WEST BURTON SOLAR PROJECT – EN-010132

WEST LINDSEY DISTRICT COUNCIL – 20038501

ISSUE SPECIFIC HEARING 5 – ENVIRONMENTAL MATTERS- GENERAL

SUMMARY OF HEARING

Figure 1. Location of heritage assets associated with Stow Park Deer Park, Stow Deserted Medieval Village and a possible early medieval settlement in the west of West Burton 3.

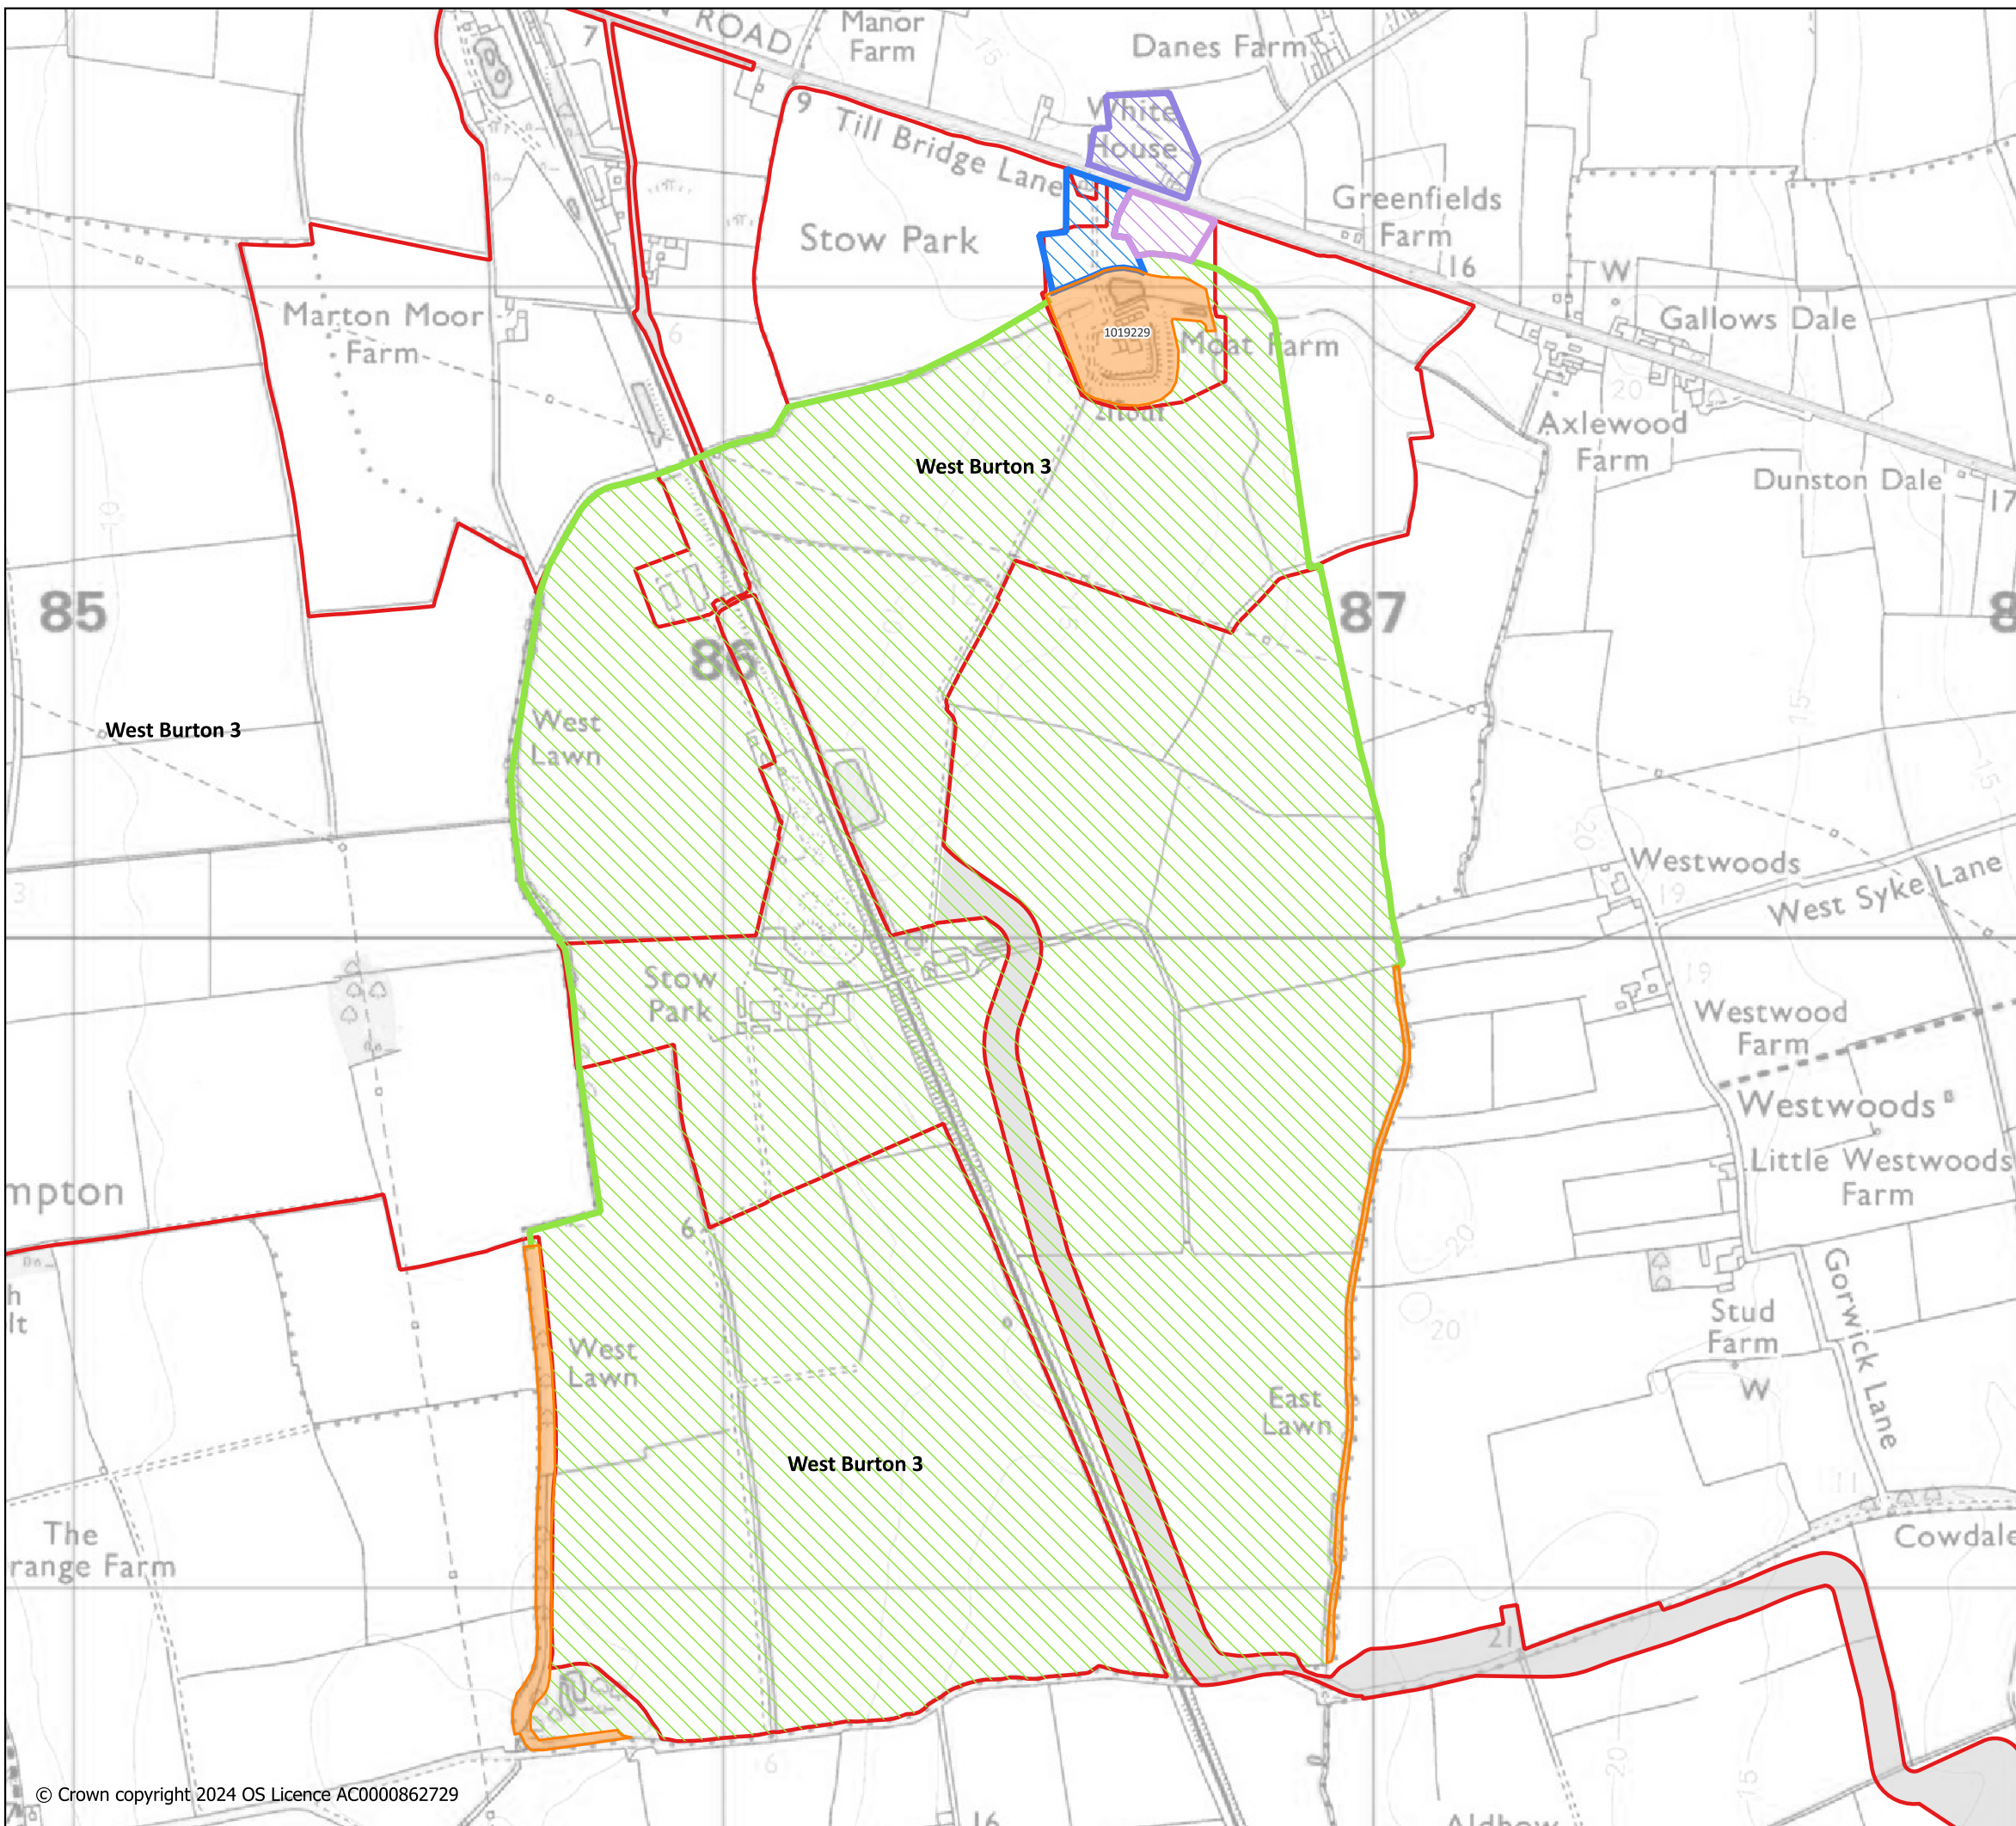
d.	The assessment of effects of the scheme on the Stow Park medieval bishop's palace and deer park, the	WLDC maintains its view set out in the LIR and Written Representation with regard to the unacceptable harm the West Burton Solar Project will have on the Scheduled Monument at Stow Park Medieval Bishop's Palace and Deer Park.

WLDC noted the discussion regarding the degree of harm that the proposal will have upon the Stow Park medieval bishop's palace and deer park. The ExA recognised the clear disagreement between the applicant and Historic England regarding the extent of the harm. Historic England's (HE) position is that the proposal would clearly result in 'substantial harm' being caused to the scheduled monument as a consequence of the proposed works would intrude within its setting, causing impacts which would constitute 'substantial harm'.

In response to what measures they consider could or should be taken to mitigate the impacts, HE states that their view as the statutory body is that all panels from the areas adjacent (within) the Scheduled Monument would remove their concerns. HE stated that, in their view, it is very unusual that this has not already been designed out considering the designation of the asset.

WLDC wholly concurs with the view expressed by HE which reflects fundamental objection to the application set out in the Local Impact Report and Written Representation, in that unacceptable harm will be caused to the medieval bishop’s palace and deer park Scheduled Monument.

The schedule description for the bishop’s palace and deer park scheduled monument is clear in that the historic importance of the designated Scheduled Monuments of the Bishop’s Palace and the park pales are defined and bound by the deer park to which they relate and frame. The park was naturally a rural landscape and it is this character that is integral to the importance of the Scheduled Monument. Any degradation or erosion of that landscape character will cause significant harm to the setting of the Scheduled Monuments.

The West Burton Solar Project ES concludes a ‘large adverse’ impact upon the bishops palace Scheduled Monument. WLDC consider this to equate to ‘substantial harm’ for the purposes of NPS, NPPS and CLLP policy.

WLDC considers that the significance of an medieval deer park relates not only to the containment and protection of deer, but also the wider character of the landscape. As a consequence, this setting would experience substantial harm by the loss of rural character that would entail by the existence of solar panels.

WLDC considers that the setting of the Scheduled Monuments would be materially harmed through the construction of solar panels and the fact no direct physical harm to the Scheduled Monuments does not avoid the statutory duty and policy requirement to conserve their setting.

WLDC notes and agrees with HE's position that the removal of panels within the setting of the scheduled monument is required in order for the impacts to be acceptable. If the panels and infrastructure are not removed, WLDC's view is that the DCO application should be refused on the basis of unacceptable substantial harm that would be caused to the bishop's palace and deer park Scheduled Monument.
